From: Nicola Swann [REDACTED]
Sent: 06 January 2021 13:47
To: Planning.Responses <Planning.Responses@arun.gov.uk>
Subject: Pagham responses

Pagham Parish Council considered the following applications at a meeting of its Planning Committee held on 5th January 2021. It has the associated comments to make:

Proposed Ground Floor Plan & Roof Plan
Proposed Elevations
August 2020

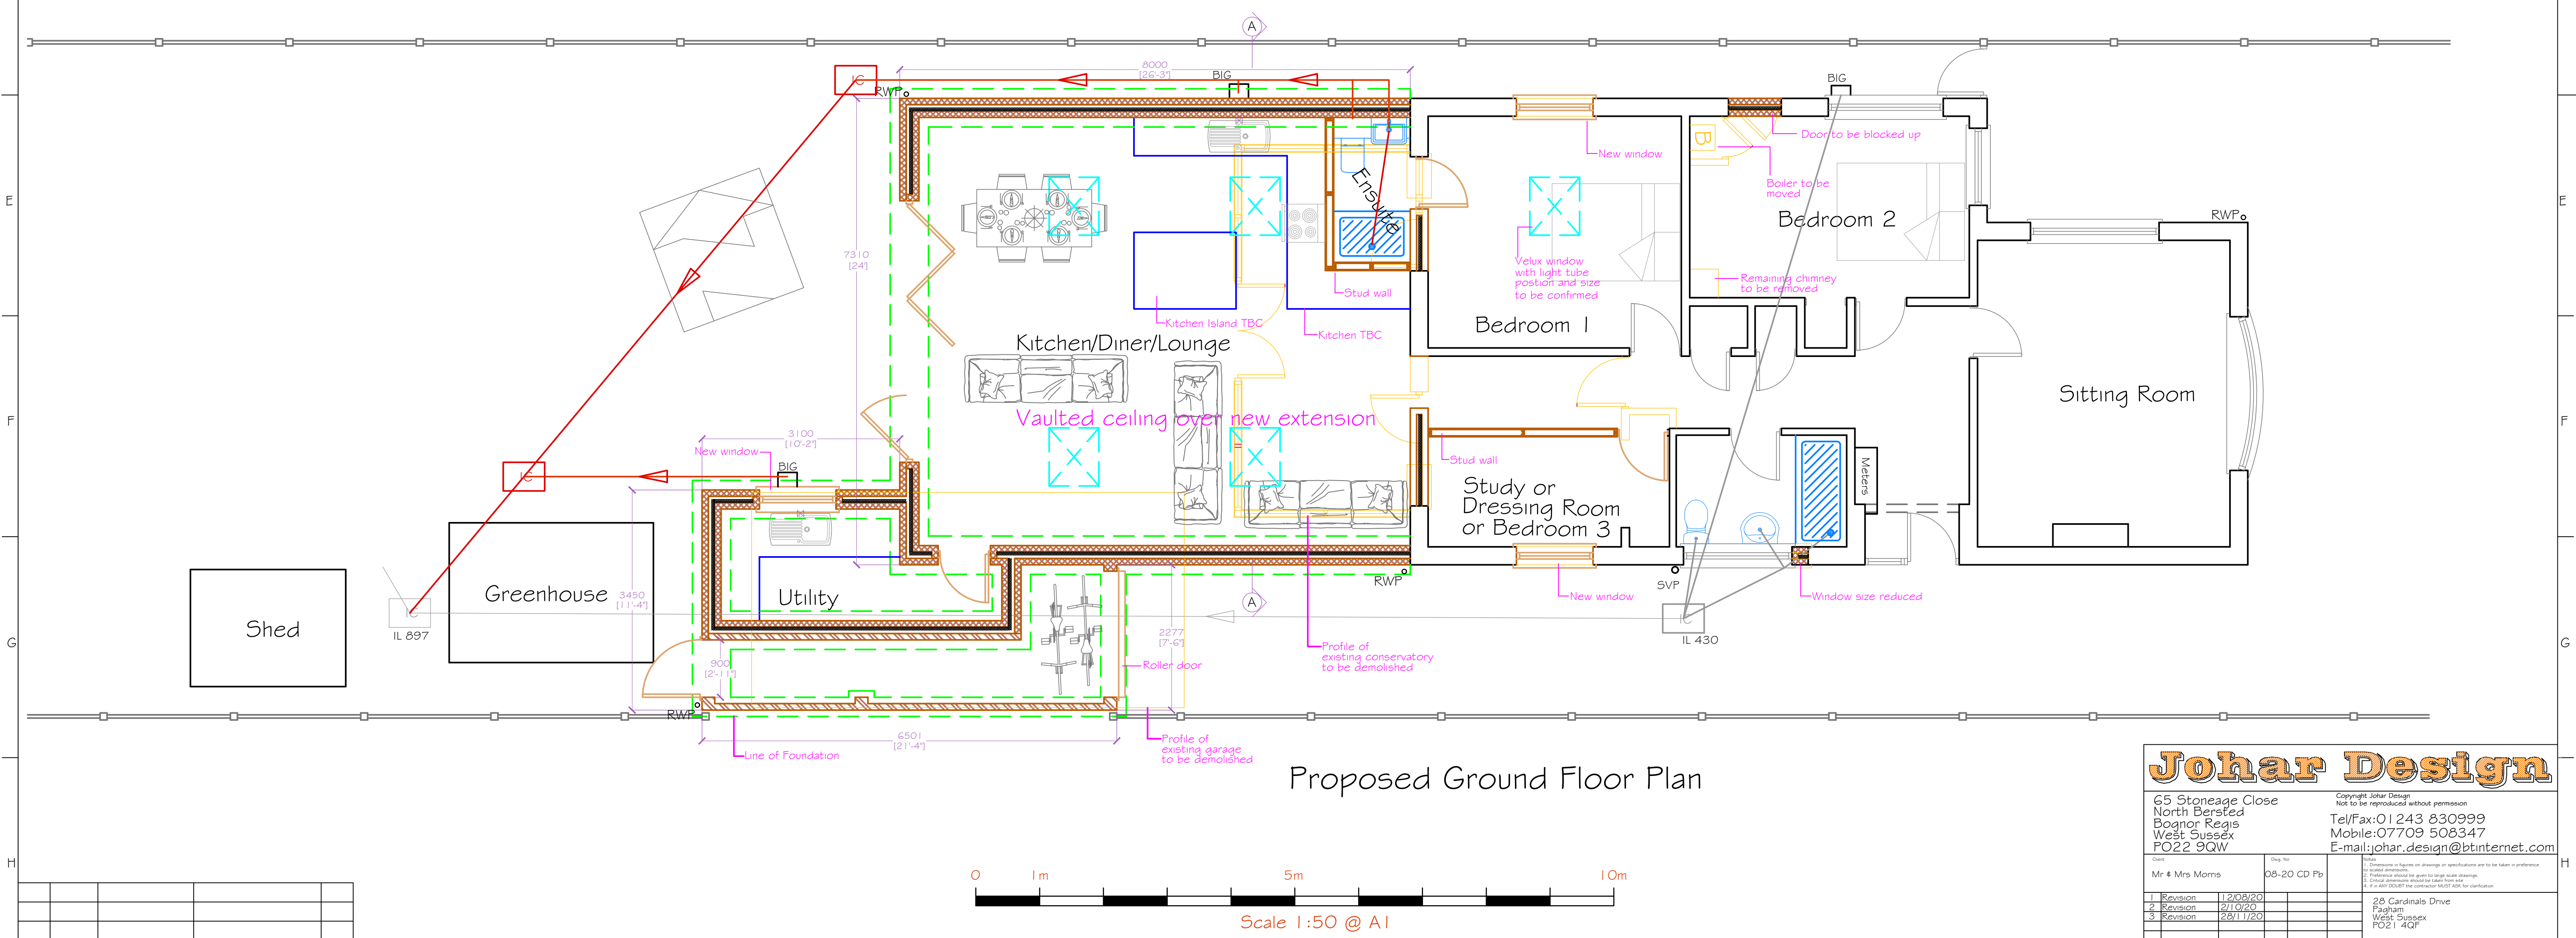
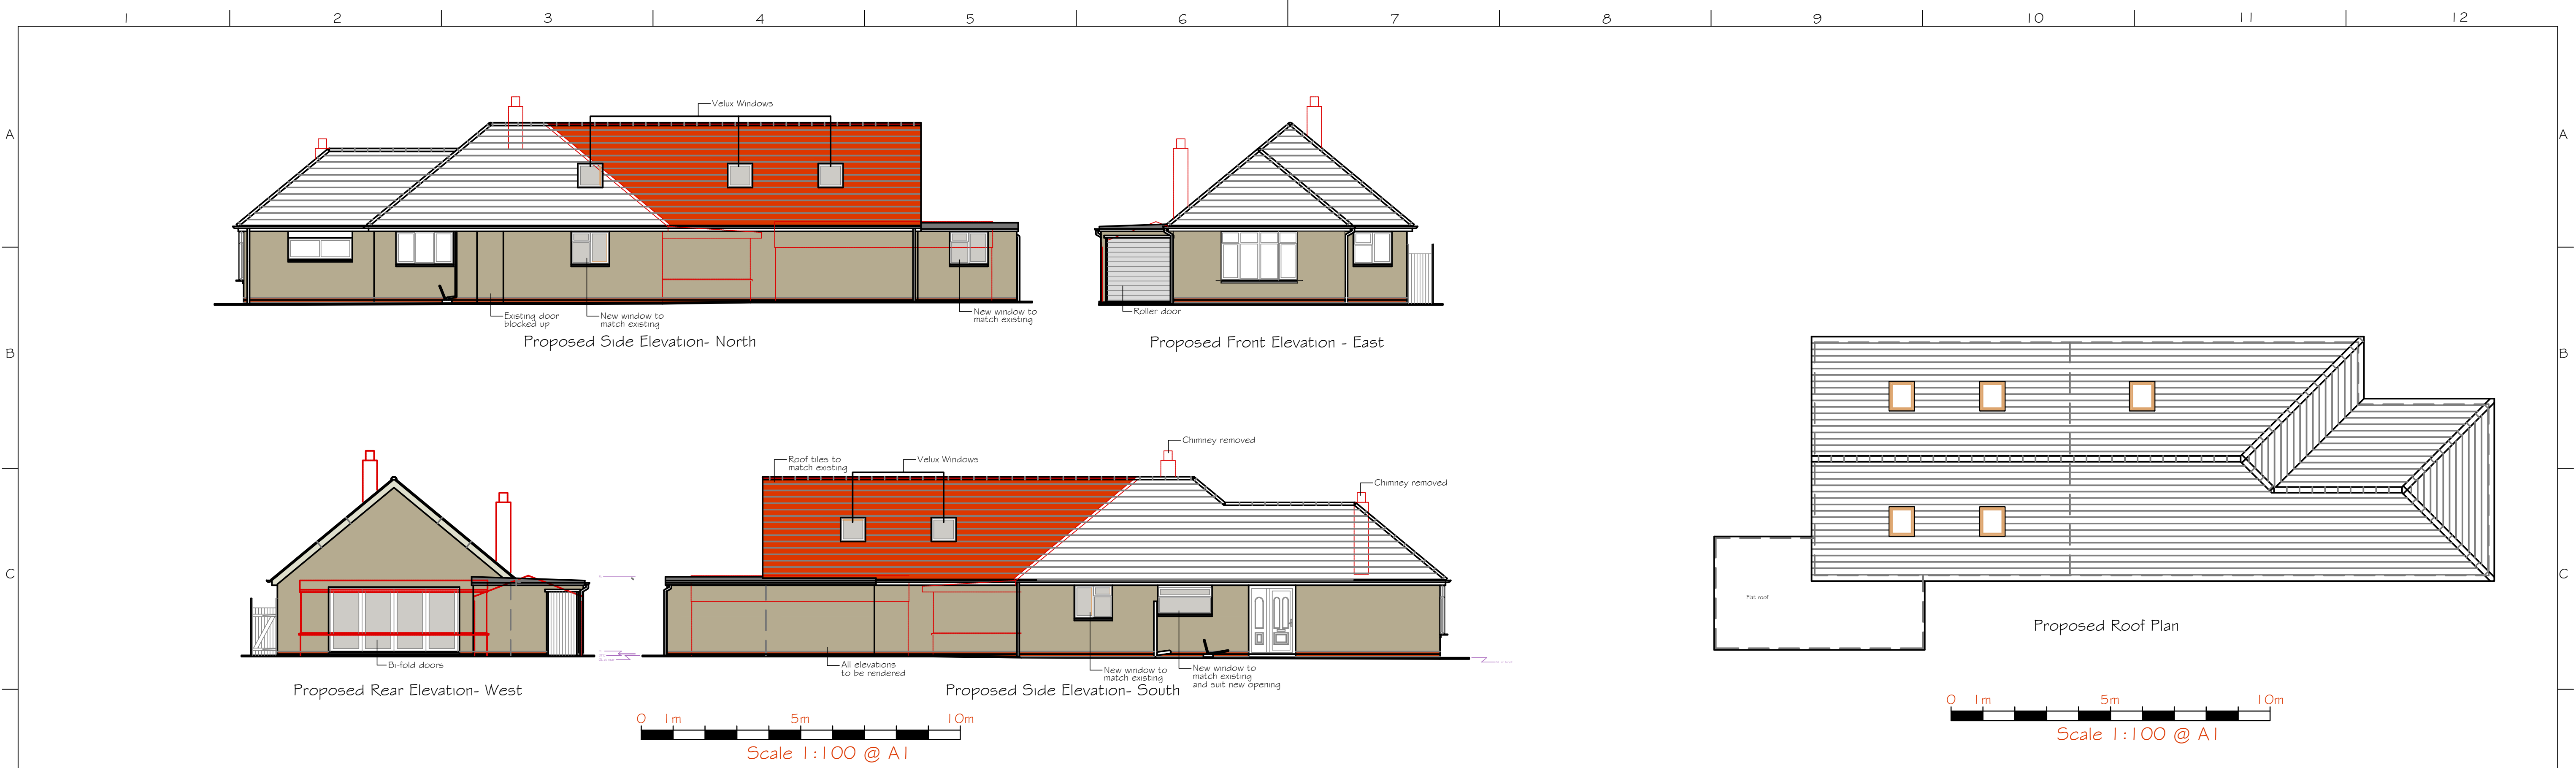
P/122/20/HH – 28 Cardinals drive Pagham PO21 4QF – single storey rear extension to form kitchen/diner/lounge and utility area with bike store under pitched vaulted roof. Cllr Mrs Hall declared an interest in this application and withdrew from discussion. She took no part in the vote on the resolution of the Council regarding this matter. RESOLVED: the Council wished to OBJECT to this application. The proposals represented overdevelopment of the site, and would be overbearing on neighbouring property, contrary to policy D DM1 of the Arun Local Plan
